Application Ref: 3/2021/0676
Date Inspected: 16/08/2021
Officer: LE

DELEGATED ITEM FILE REPORT:

Decision REFUSE

Development Description: Regularisation of unauthorised outbuilding ancillary to dwelling.
Site Address/Location: Thorneyholme Hall, Newton Road, Dunsop Bridge

Scale	Date
1:100@A2	March 2017
Drawn	Drwg No
PL	1178-PL-23E

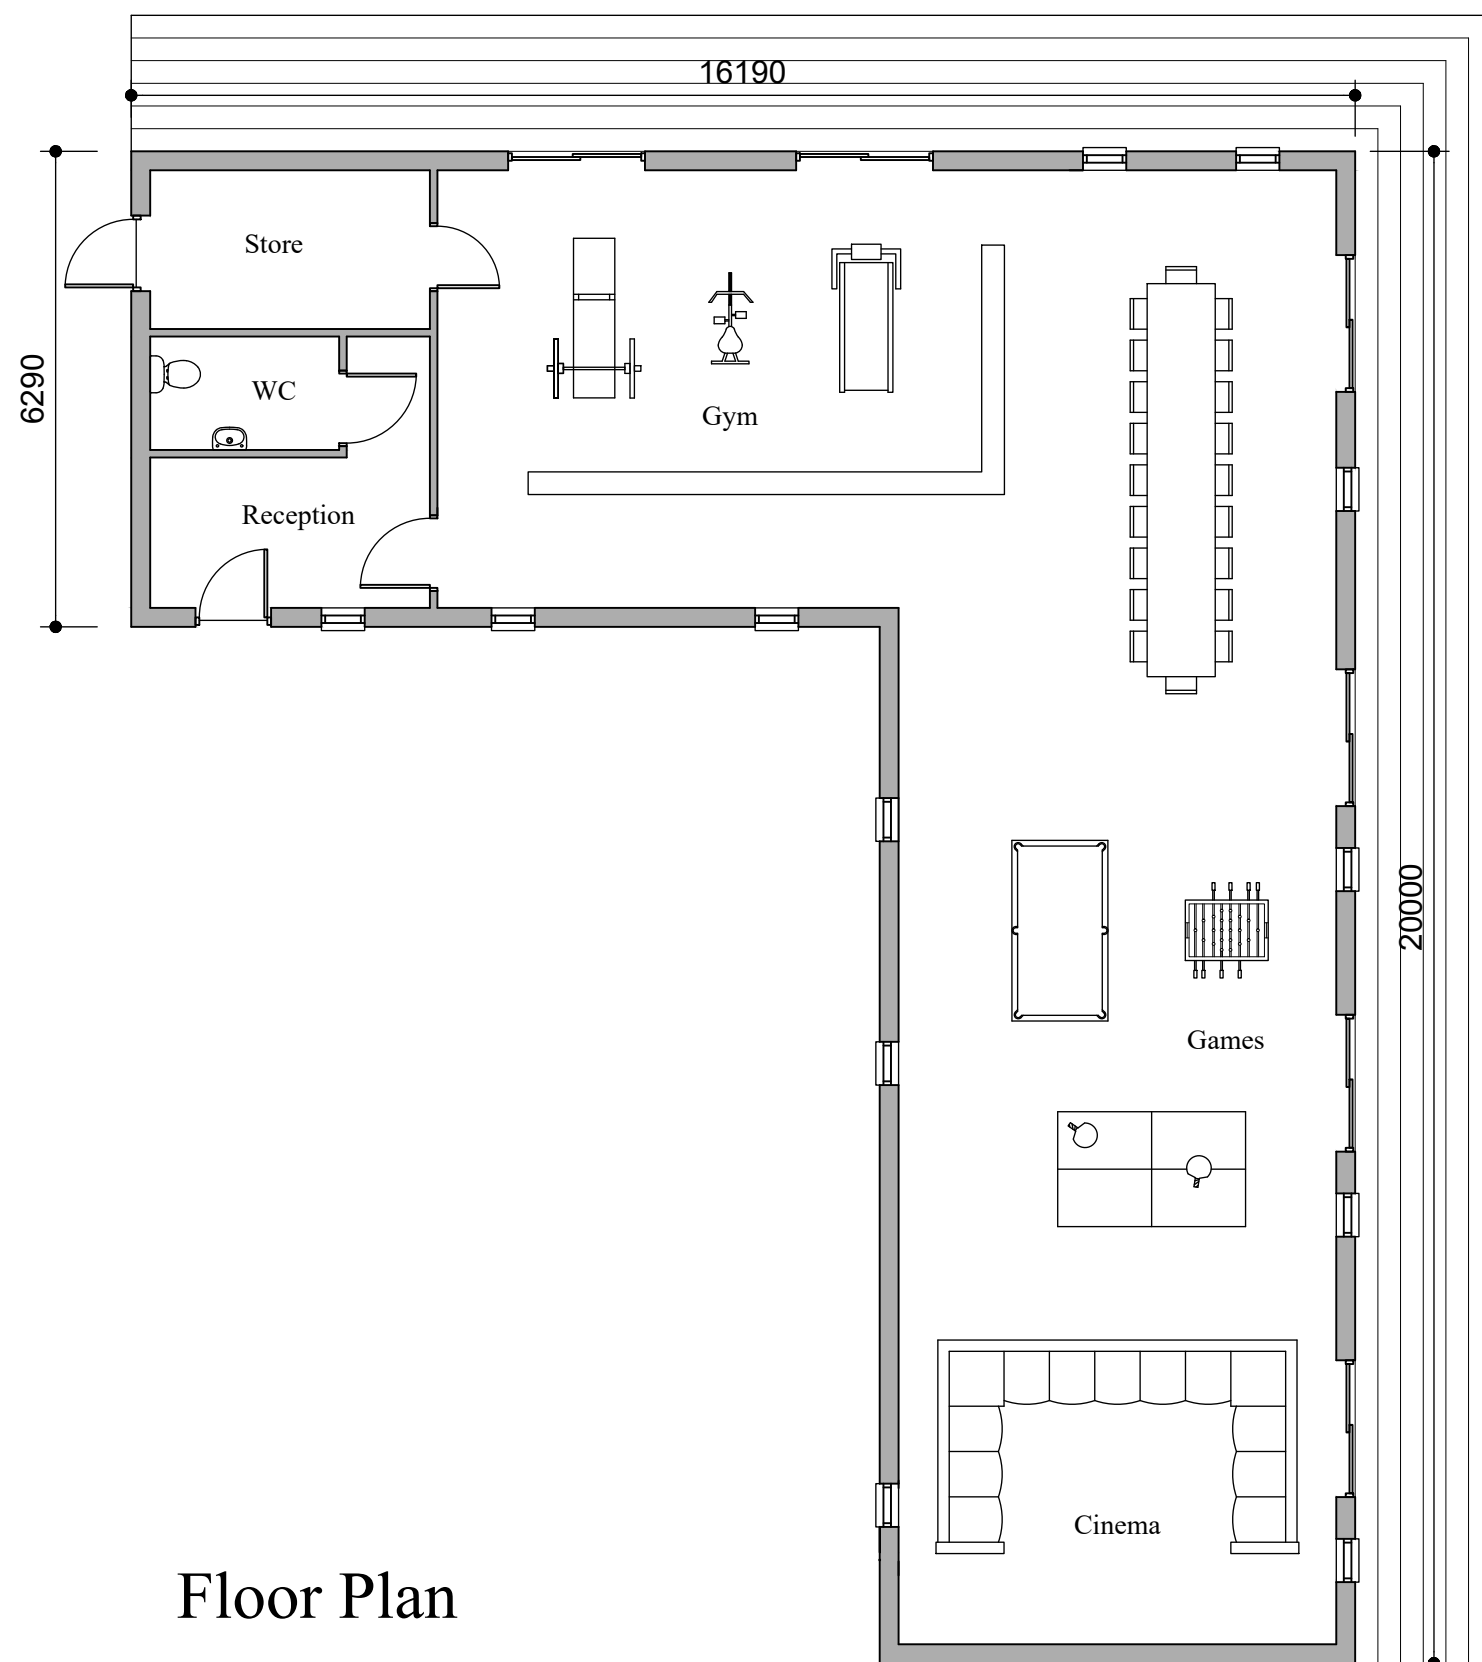
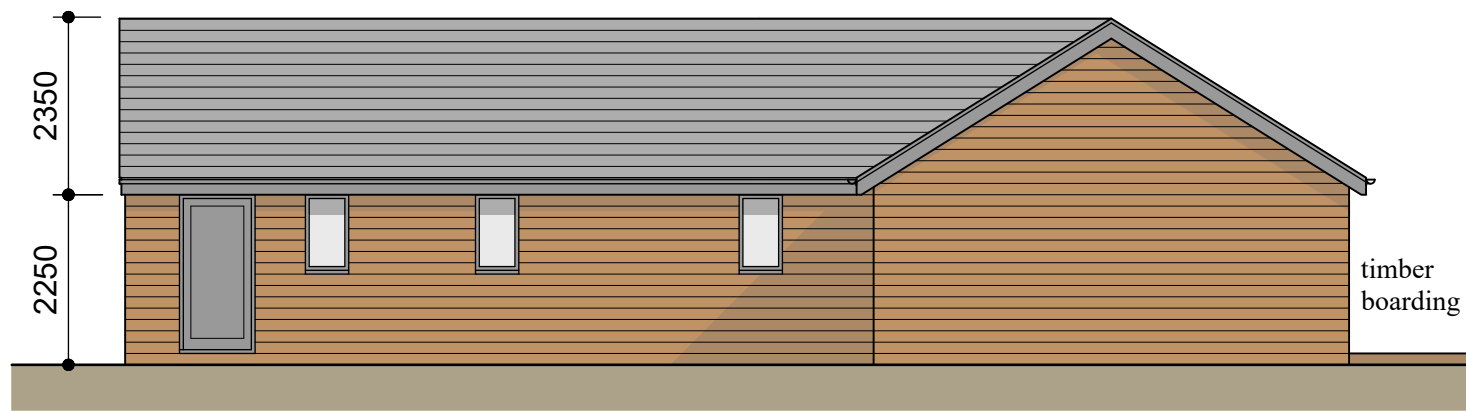
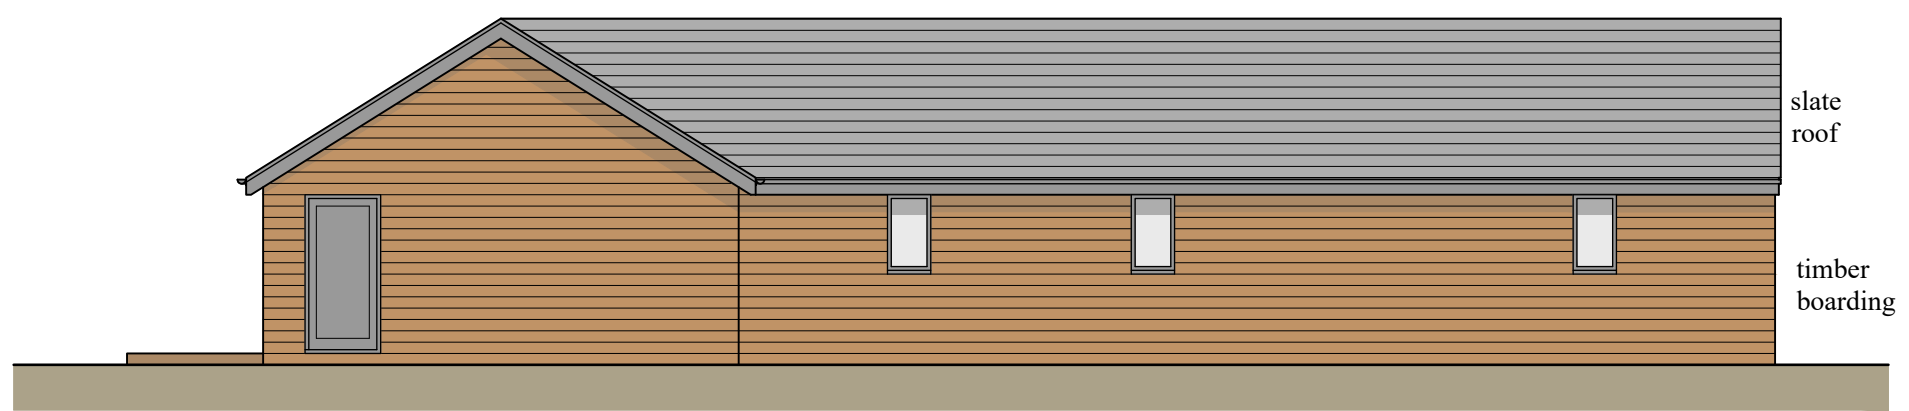
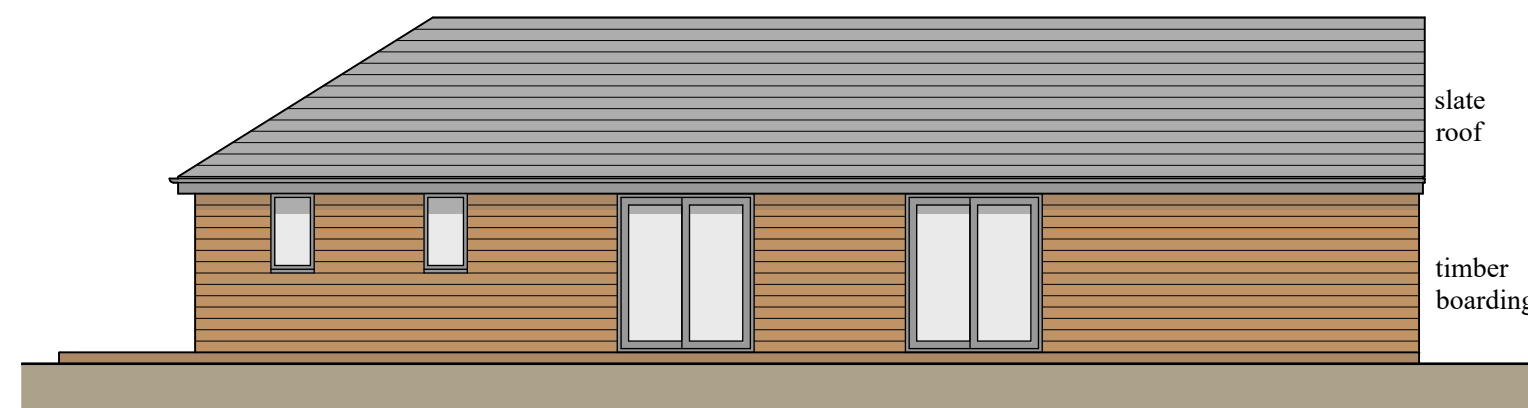
The application is confusing due to the use of old drawings / documents which have annotations referring to a cookery school. However it is understood that the building is "ancillary" accommodation to the dwelling house to be used as a games / cinema room and the change of use of the Hall and construction of a cookery school is not to be implemented.

The planning officer visited the site and although internal access was not possible the building on site appears to broadly reflect the floor plans and it is in the process of being fitted out with utilities.

bedrooms and extensive living accommodation including two lounges and two dining rooms. The footprint of the outbuilding, the subject of this application, is almost the same size of that of the house. Due to its scale and internal layout the new building it is capable of providing substantial primary living accommodation.

It is clad in timber which gives it a striking appearance directly against the stone and render construction of the hall and other nearby properties which are in a traditional style. It is clearly visible in long distance views and this impact will be exacerbated in the winter months when there are no leaves on the trees.

The proposal is for a large timber clad chalet type structure located adjacent to the Hall. It is visually prominent on the approach even though at the time of the site visit the trees were in full leaf. The choice of materials and scale is not respectful of the vernacular and is considered to be a over dominant feature which could not be considered to be ancillary or subservient to the main dwellinghouse, being capable of independent occupation. It is in conflict with policy DMG1 as it is not sympathetic in terms of scale, style or building materials and it will have a detrimental impact on landscape character.

| Rev F: Site Layout updated | 23-03-21 |

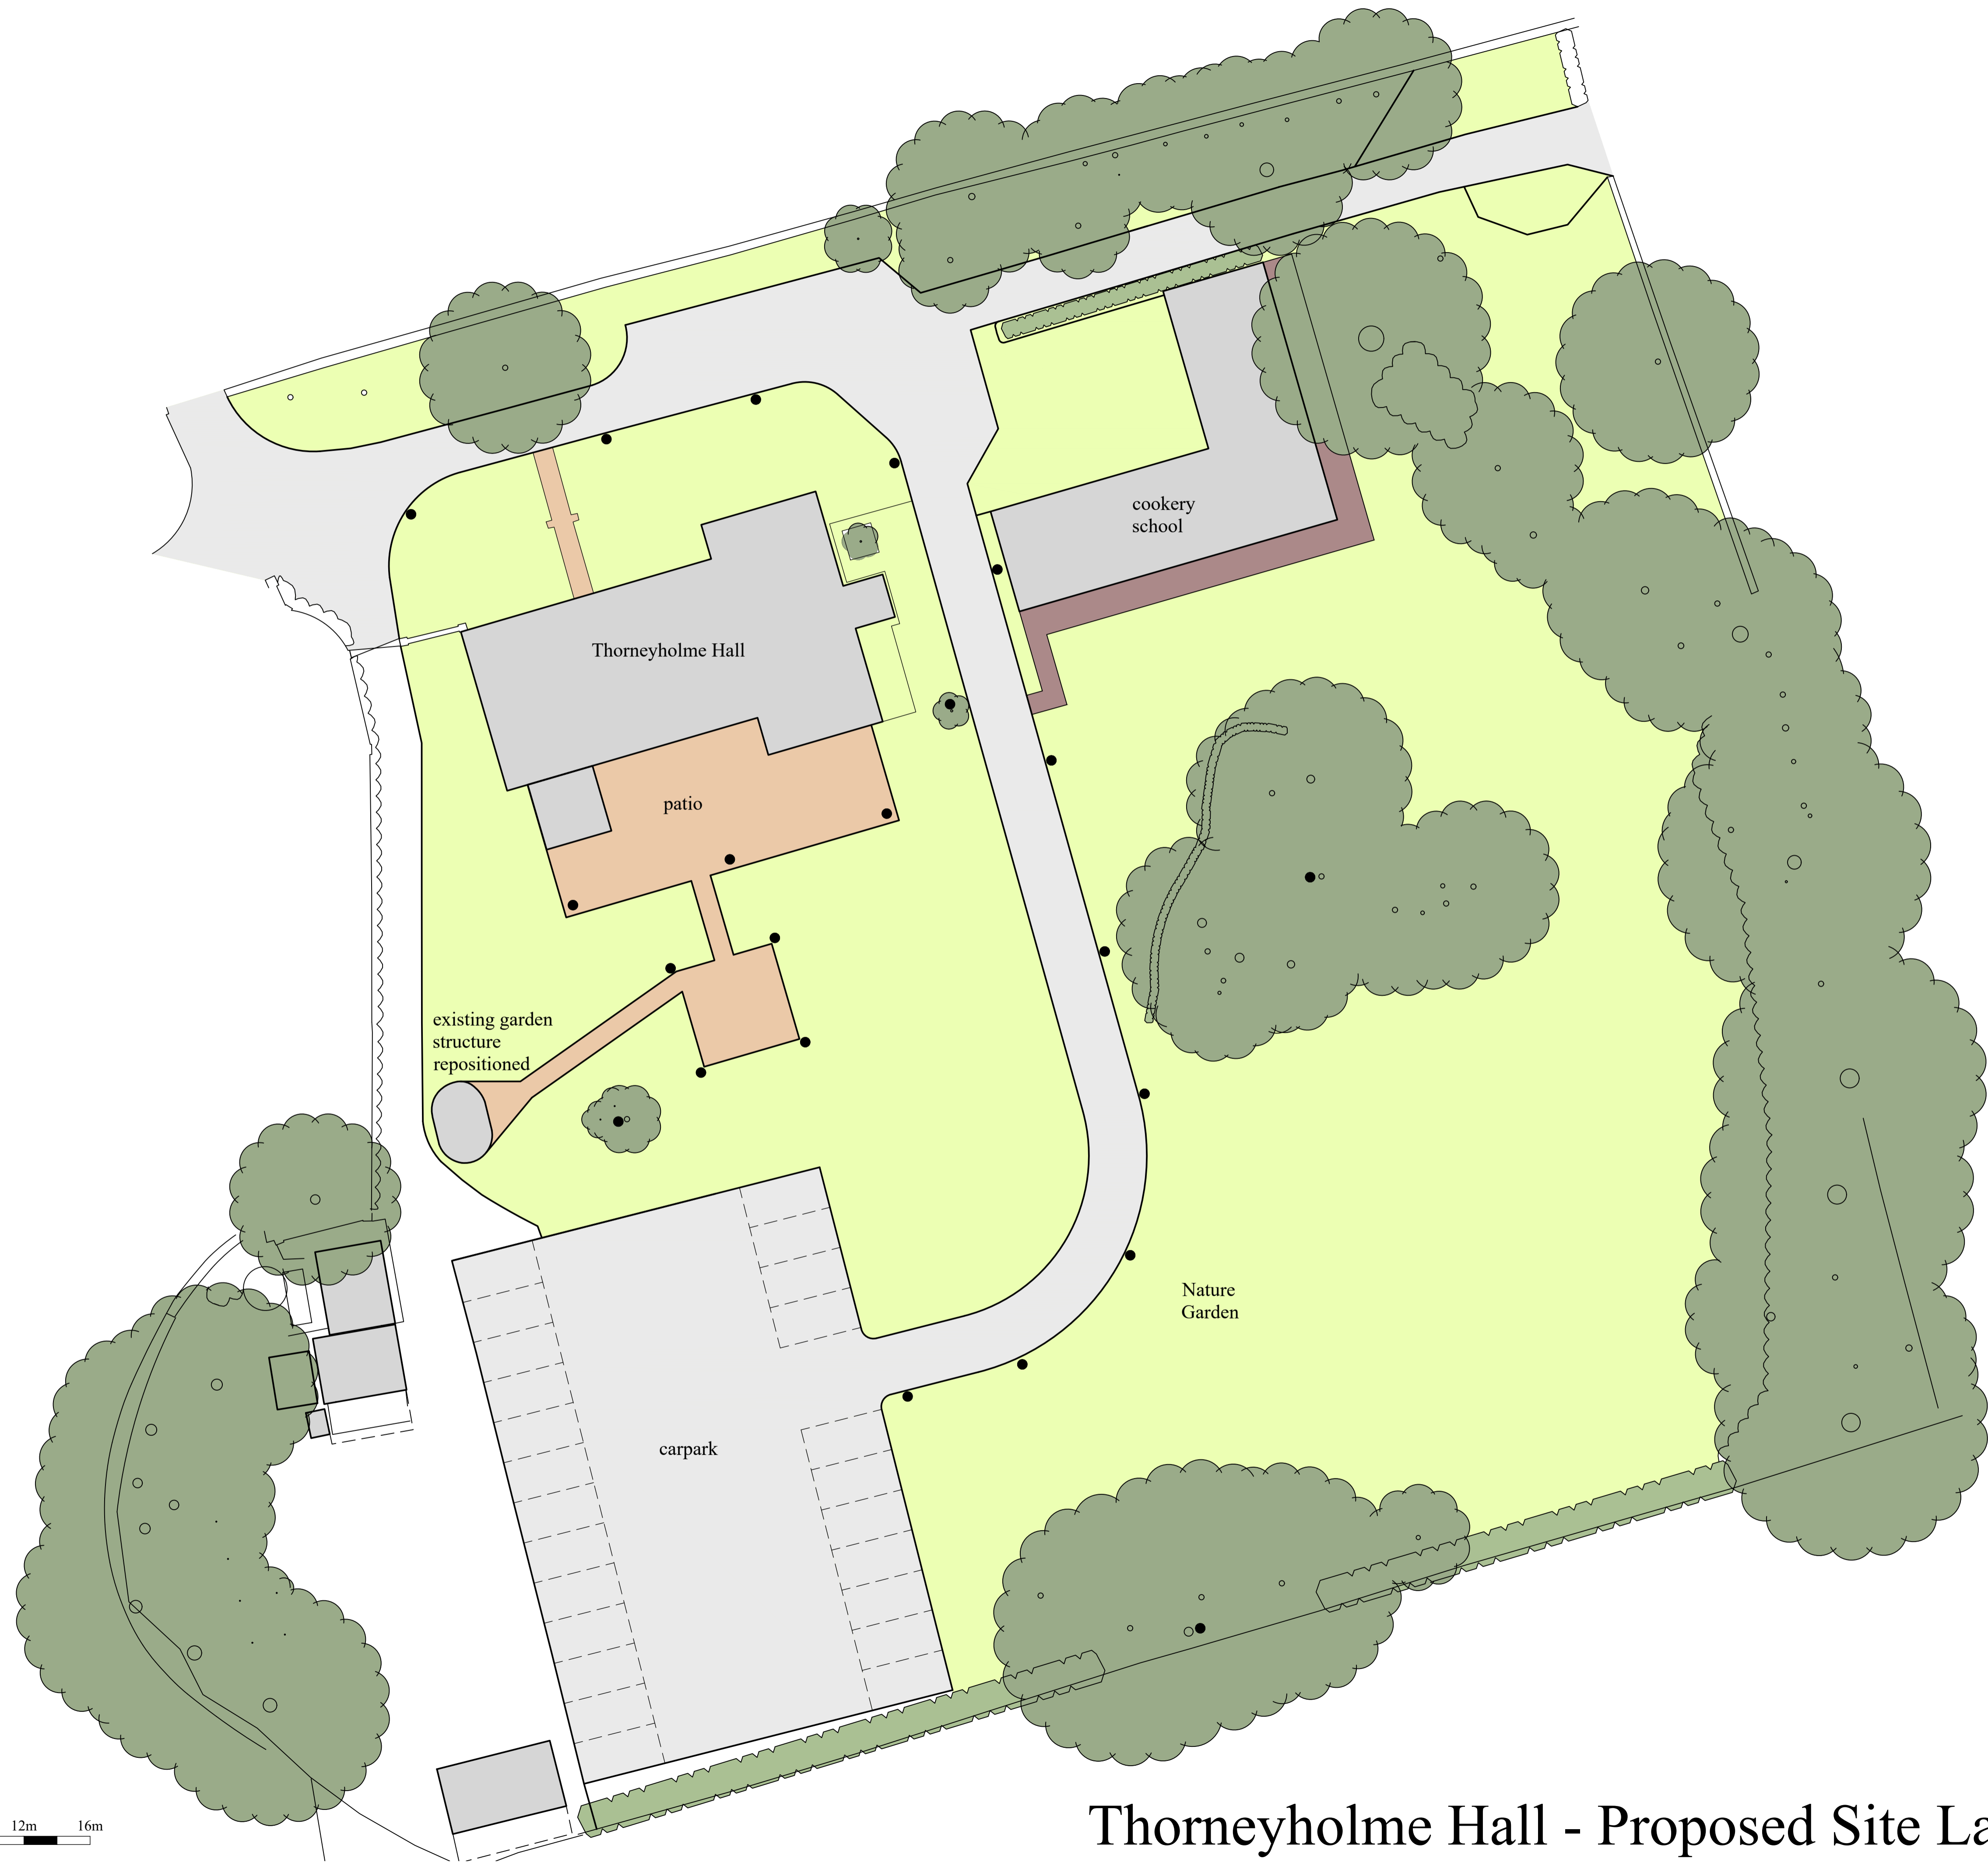
The building is located to the East of Thorneyholme Hall and is located approx. 25 metres from the boundaries of properties to the East. The scheme also includes a large car park and lighting which seems excessive for a domestic property and the site is subdivided by the centrally located driveway. However as aforementioned the proposal must be taken at face value and if used as described for ancillary accommodation to a single dwelling it is not considered that the proposed building and associated works would be detrimental in terms of the residential amenity considerations of overshadowing, loss of privacy or nuisance.

The scheme also incorporates 21 low level bollard lights along the length of the driveway and around the car park and gardens. The car park is understood to be on the site of a former stable and manege but this amount of hardstanding and lighting is considered excessive and unnecessary for a domestic property if the cookery school proposal is no longer planned.

The submitted lighting assessment concludes that the lights will not result in light spillage outside of the site so as to cause a nuisance to neighbours, and this is not disputed. However, it is still considered that they will be visible and along with the large car park will contribute to the urbanising effect of the development as a whole which will have a detrimental impact on the beauty and tranquillity of the AONB.
